# ENG-SF21021-R1-Plat.pdf Markup Summary

RETREAT AT TIMBERRIDGE
FILING NO. 2
JOB NO. 1185.20
JANUARY 4, 2021
SHEET 1 OF 7

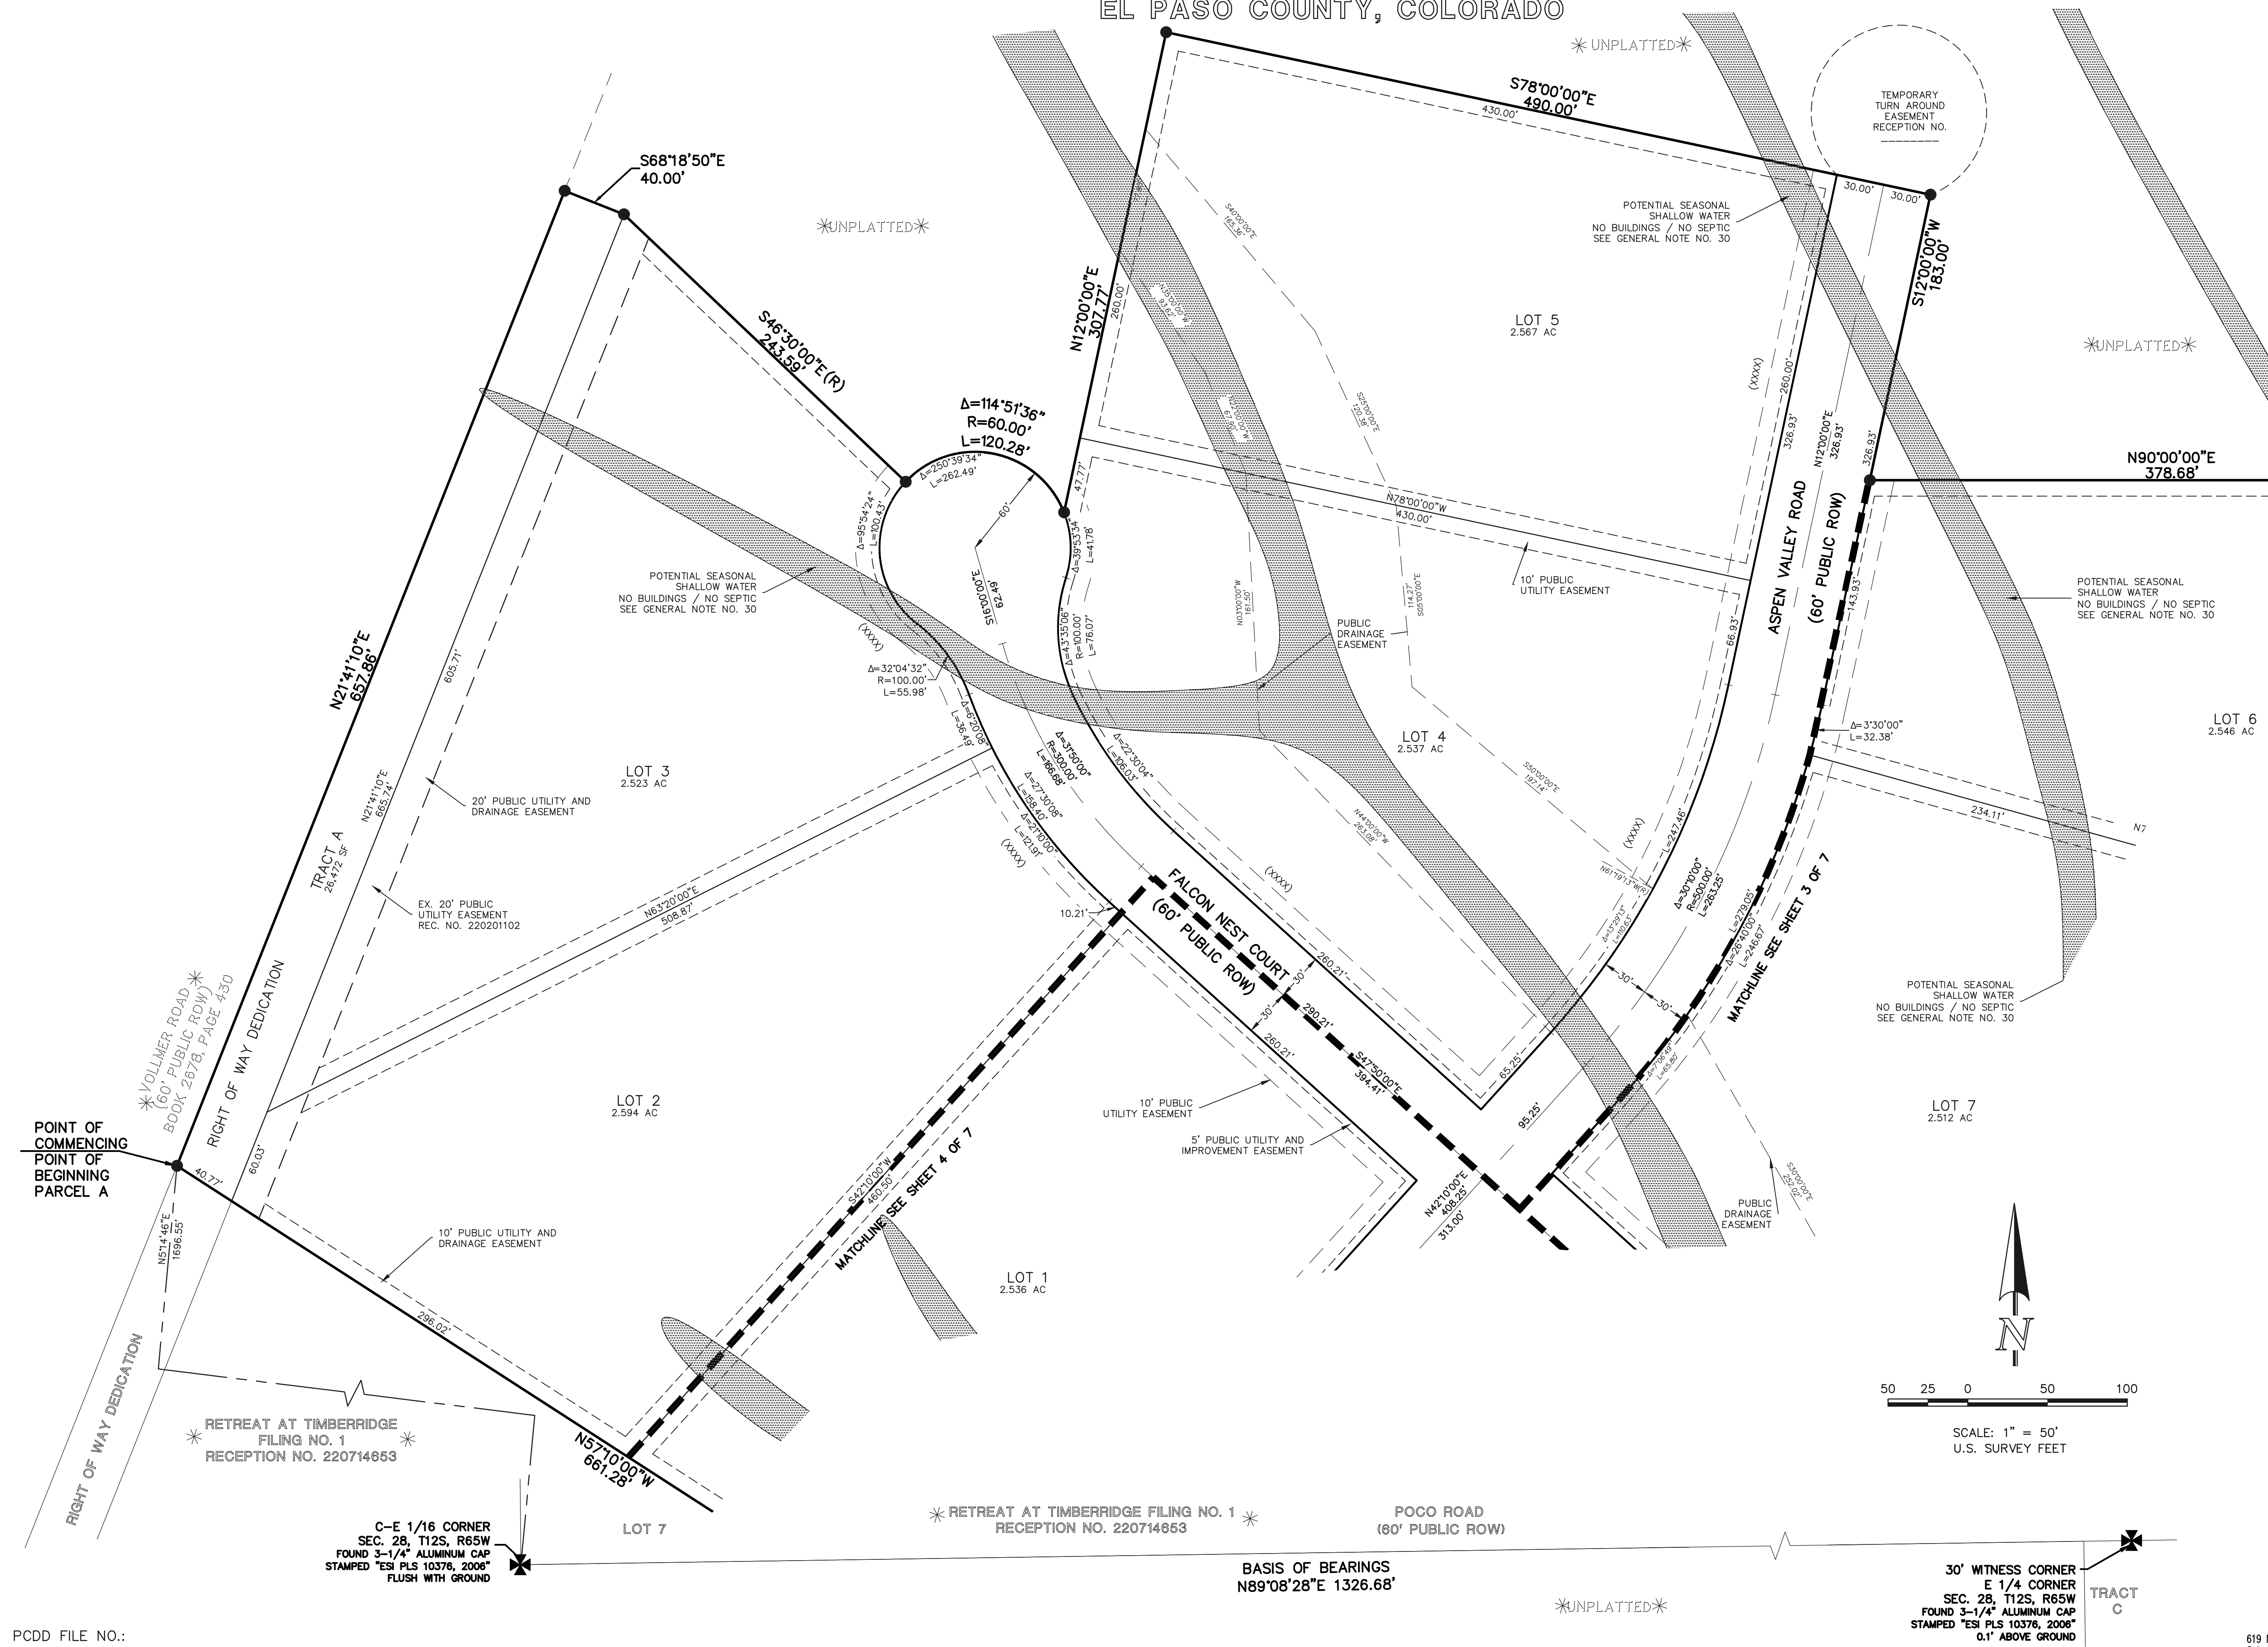
Please state who is maintaining these under drains (tied into storm sewer)

Please add a note re: the EPCDPHE req. for engineered septic per comment letter and identify the lots.

Please add the note re: PPRBD enumerations sign off and recorded at reception no. \_\_\_\_\_

please fill in fees due upon recording- is a park lands agreement proposed?

Add: Homebuilders are responsible to ensure proper drainage around structures, including elevations of foundations and window wells in relation to side-lot drainage easements and swales. Homeowners shall not change the grade of the lot or drainage swales within said easements, as constructed by the builder, in a manner that would cause adverse drainage impacts to properties.

Add note that Lots 44-53 have a 95' (?) no-build easement for ... (per FDR)

RETREAT AT TIMBERRIDGE
FILING NO. 2
JOB NO. 1185.20
JANUARY 4, 2021
SHEET 2 OF 7

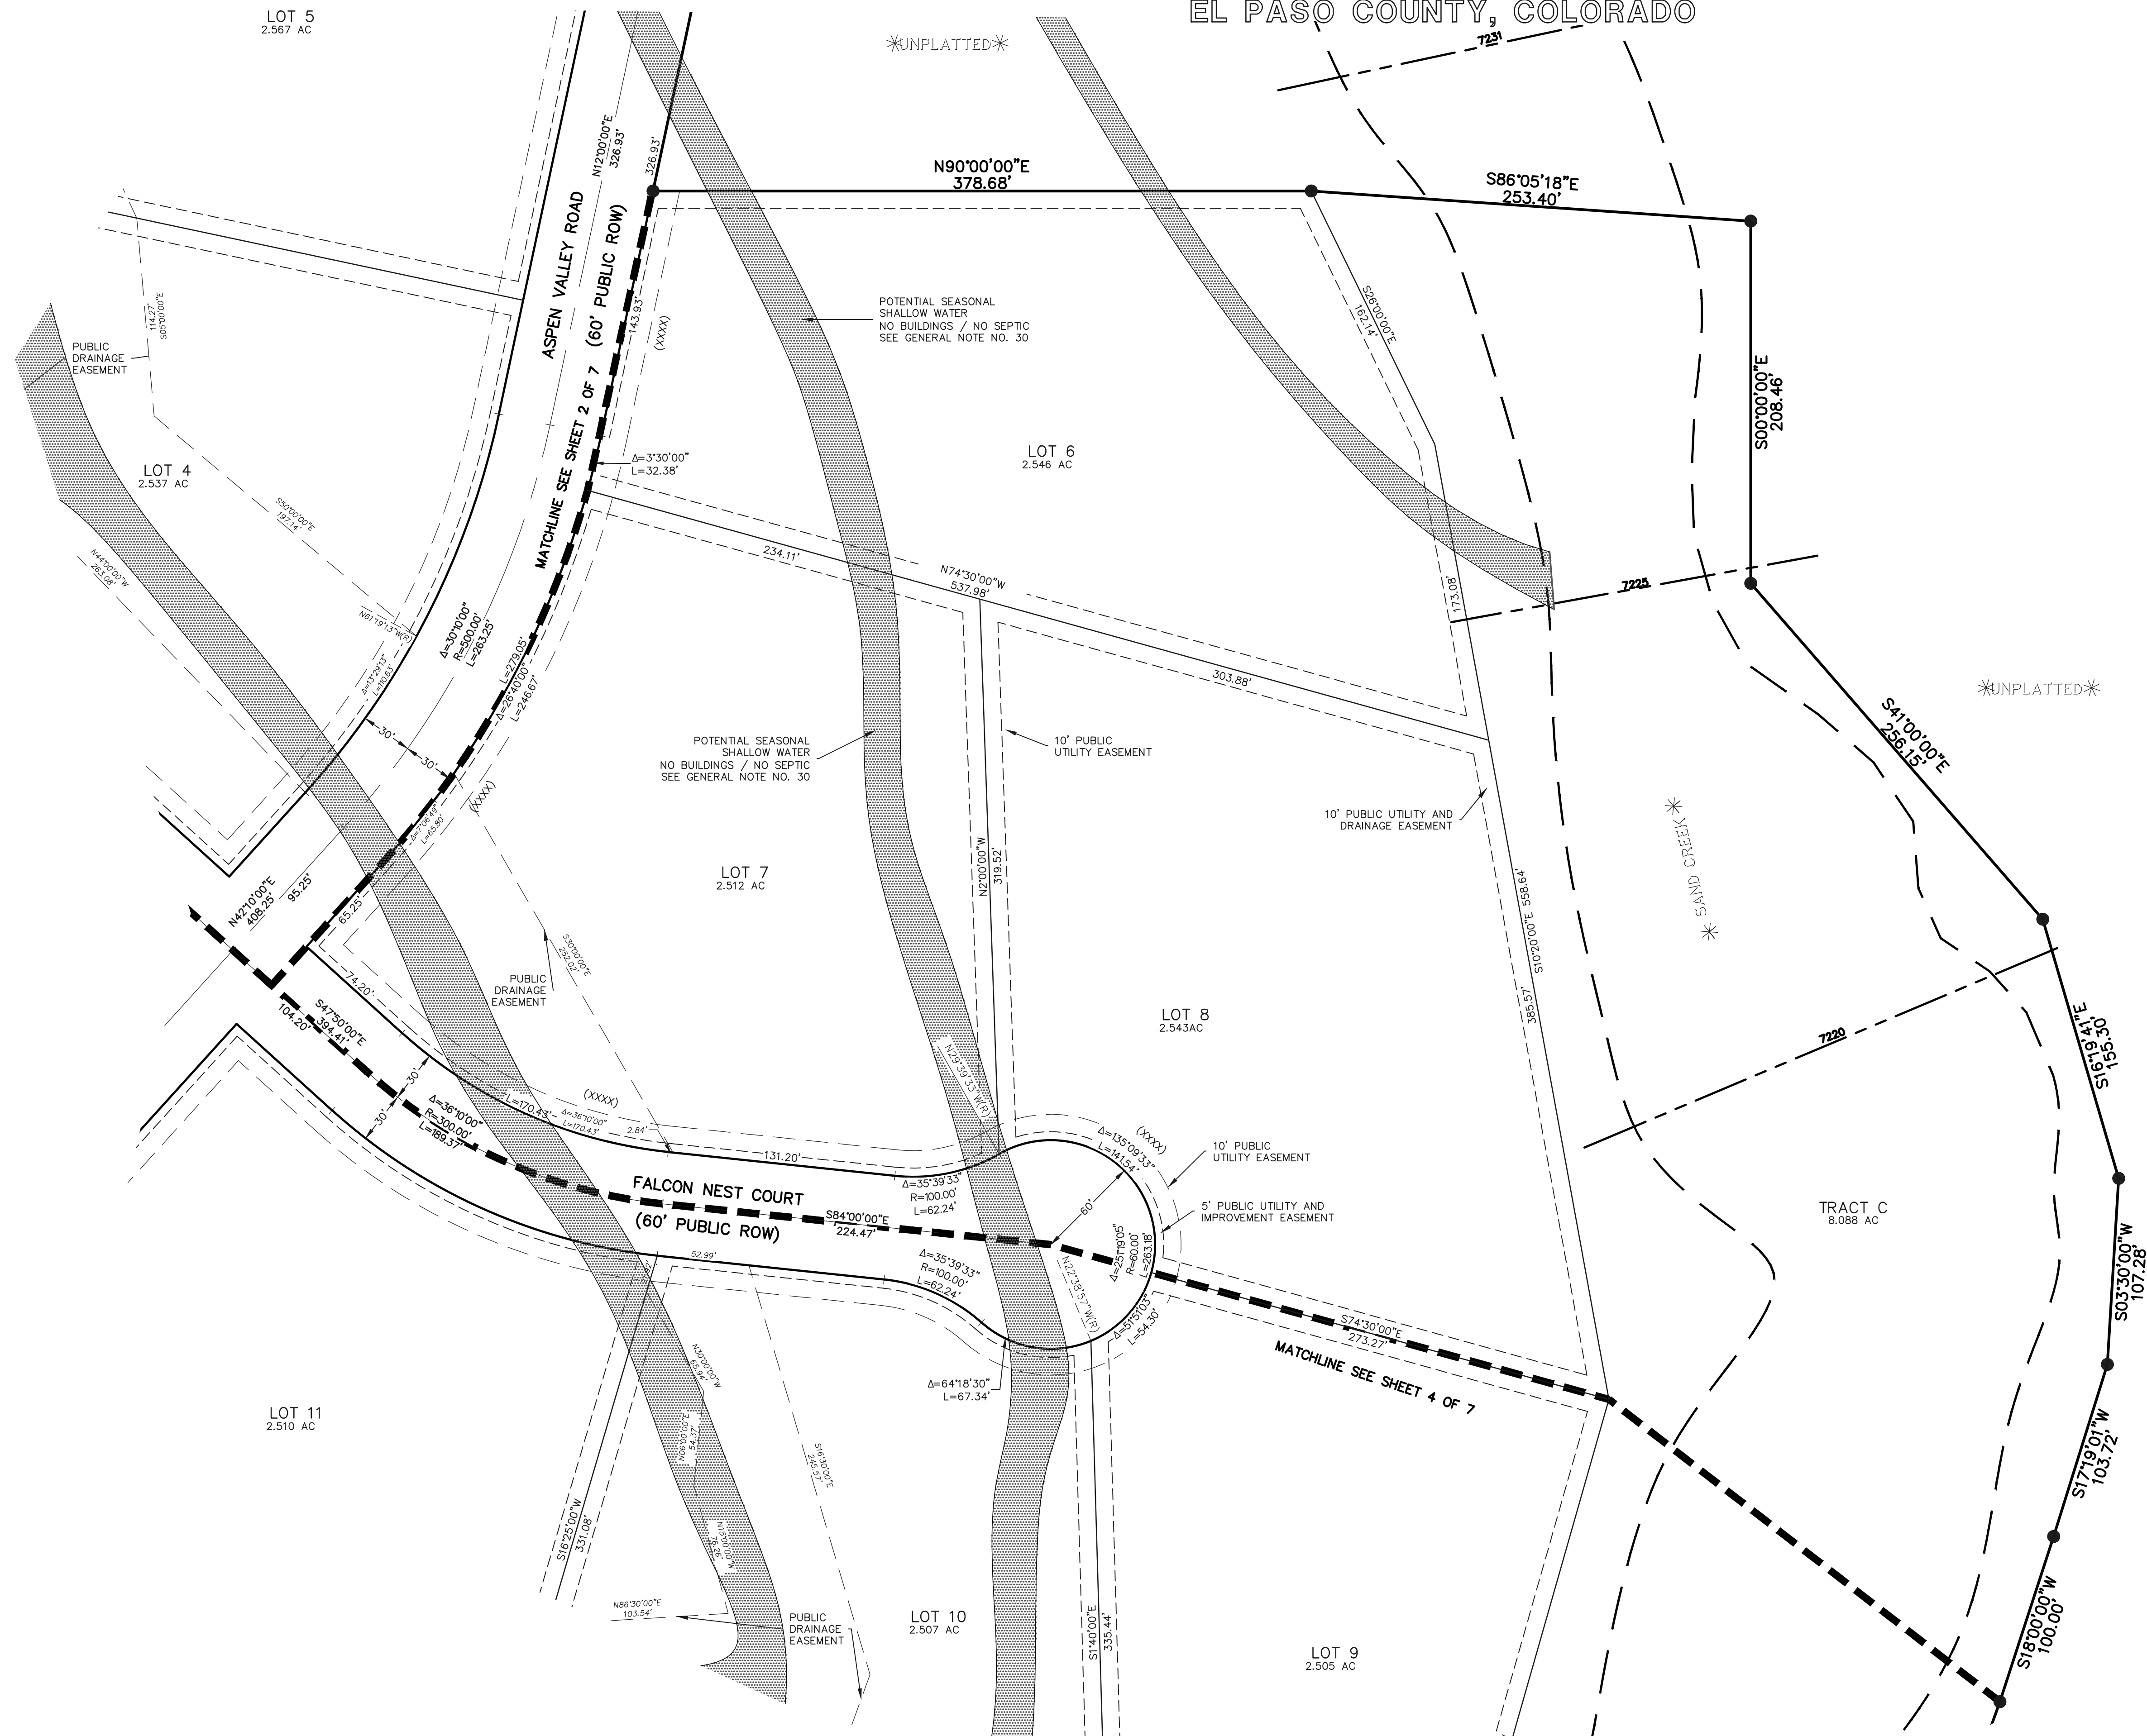
Please add to FAE and site installation and maintenance in plat note.

please add to FAE and site installation and maintenance in plat note

Delete tract designation, just label as Public ROW dedication

RETREAT AT TIMBERRIDGE
FILING NO. 2
JOB NO. 1185.20
JANUARY 4, 2021
SHEET 3 OF 7

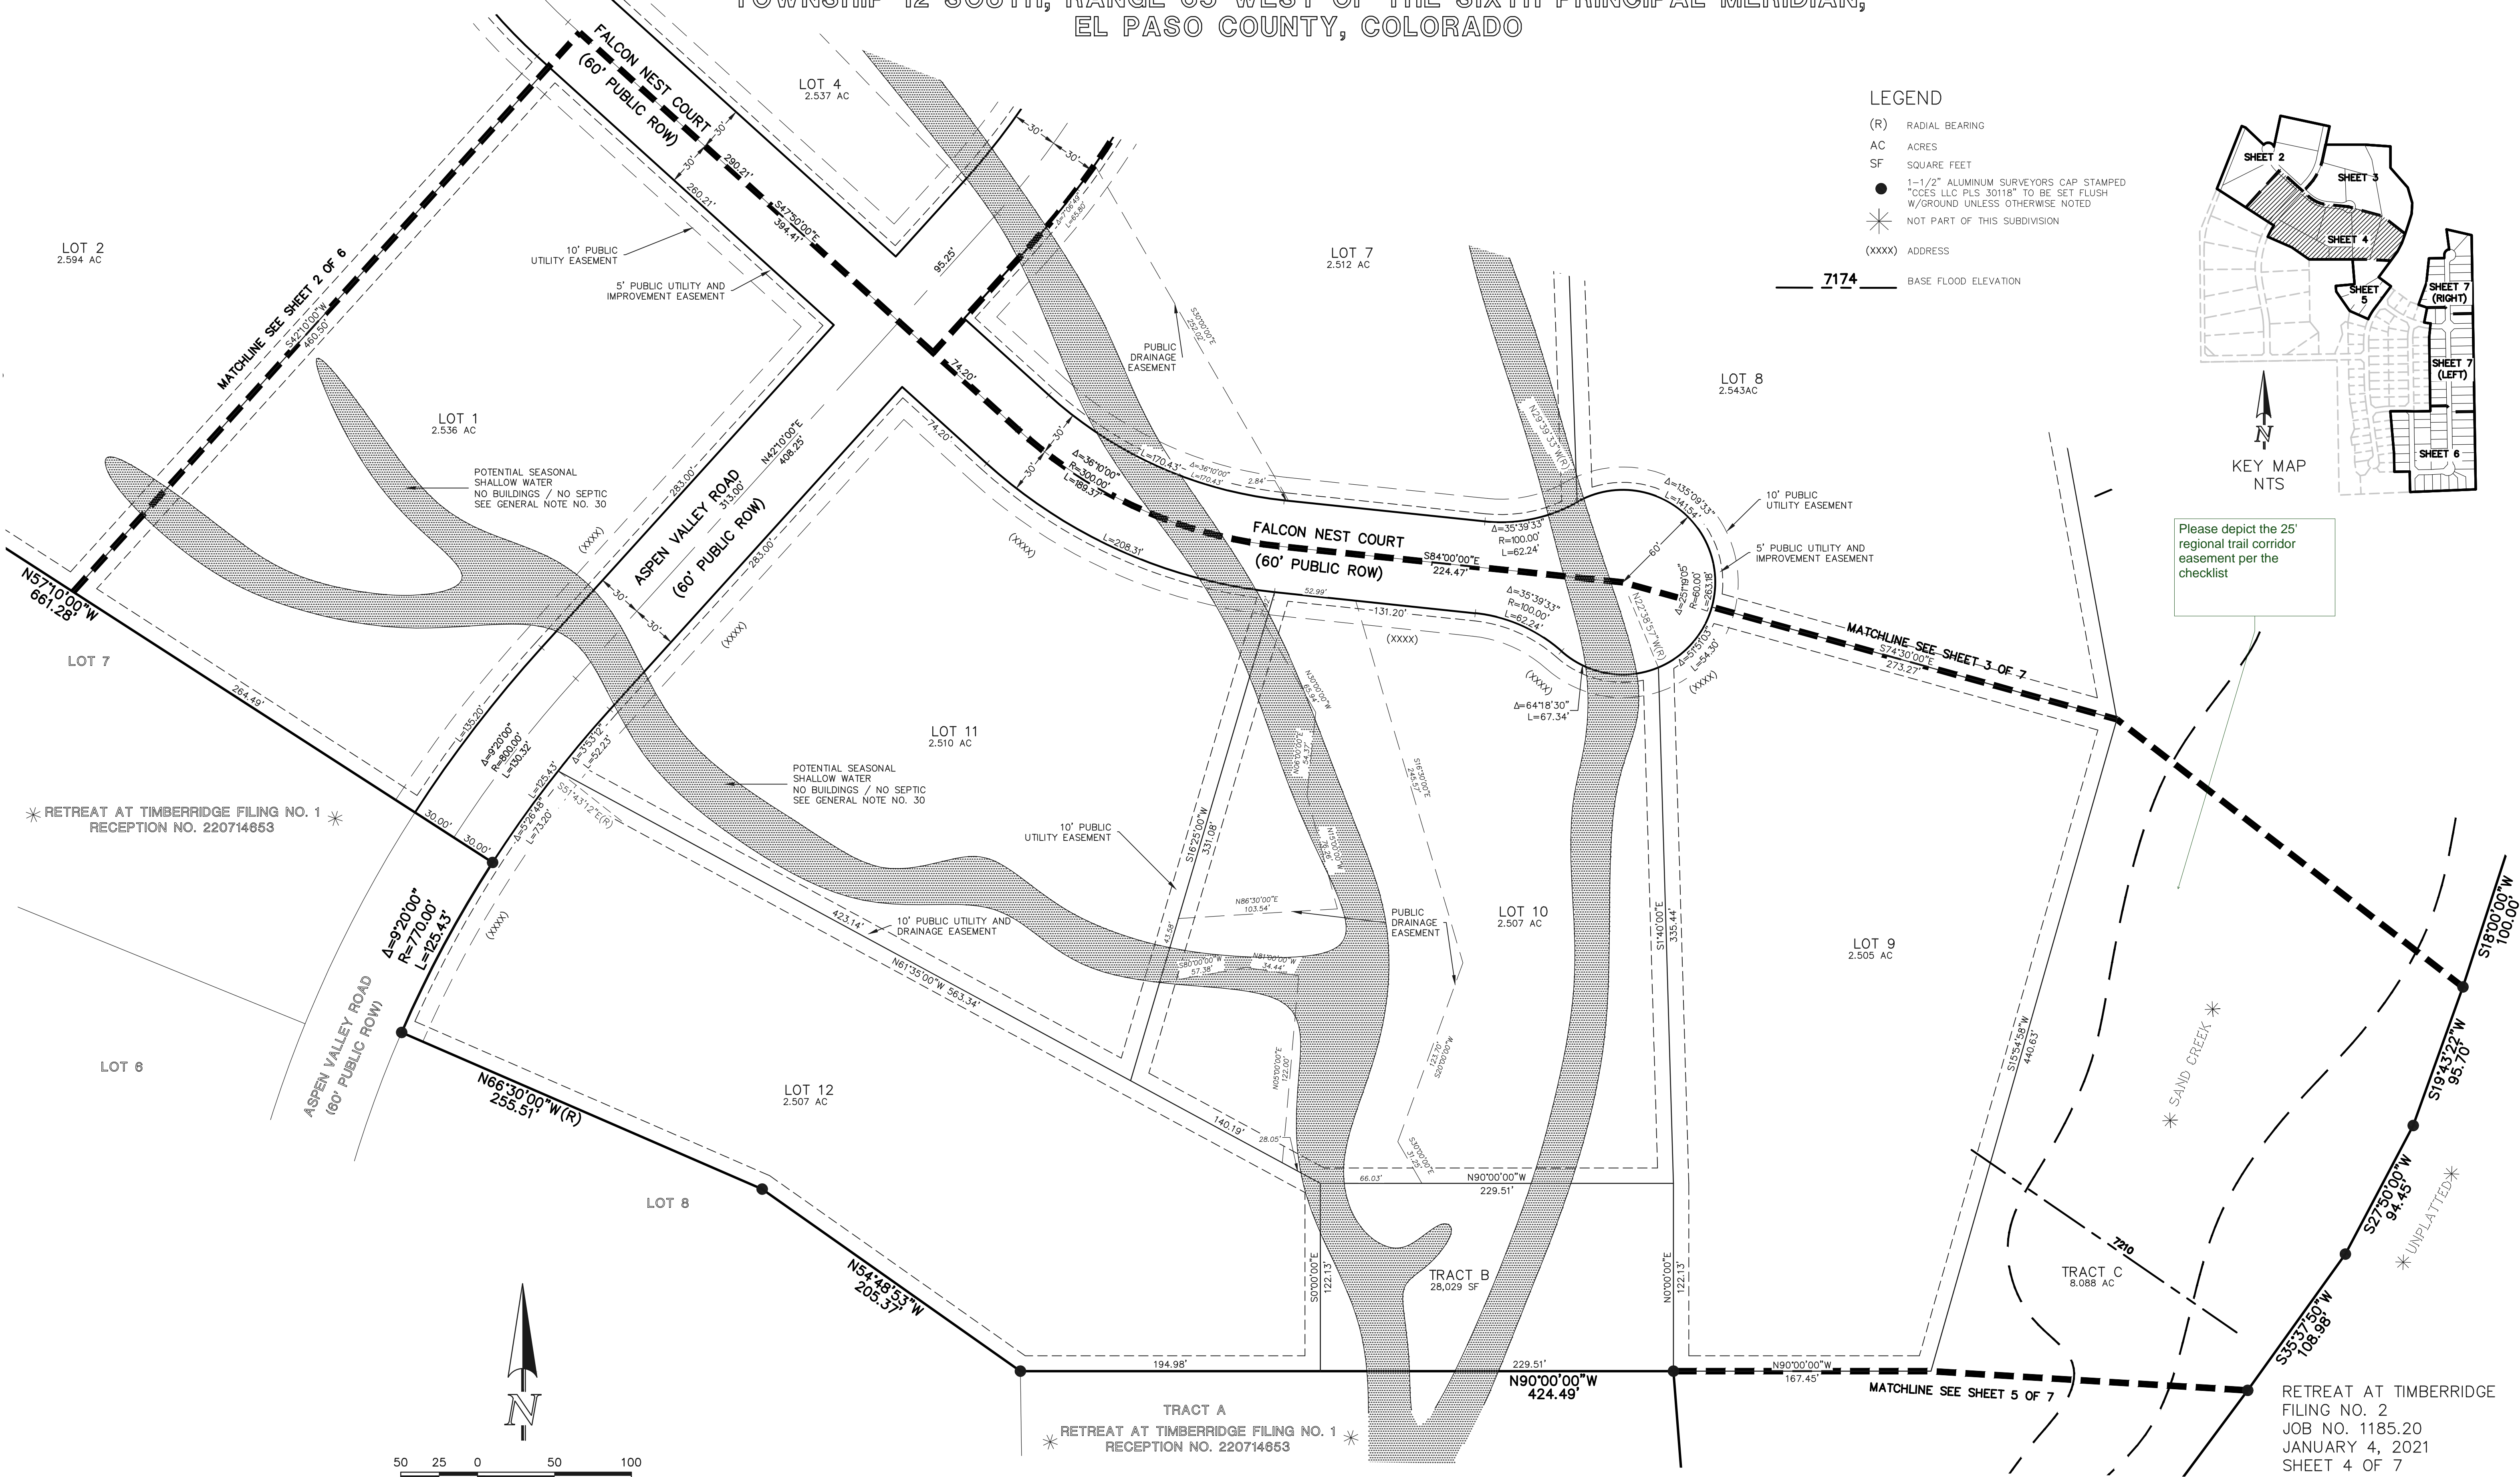
Please depict the 25' regional trail corridor easement per the checklist

is the developer constructing this for fee offset?
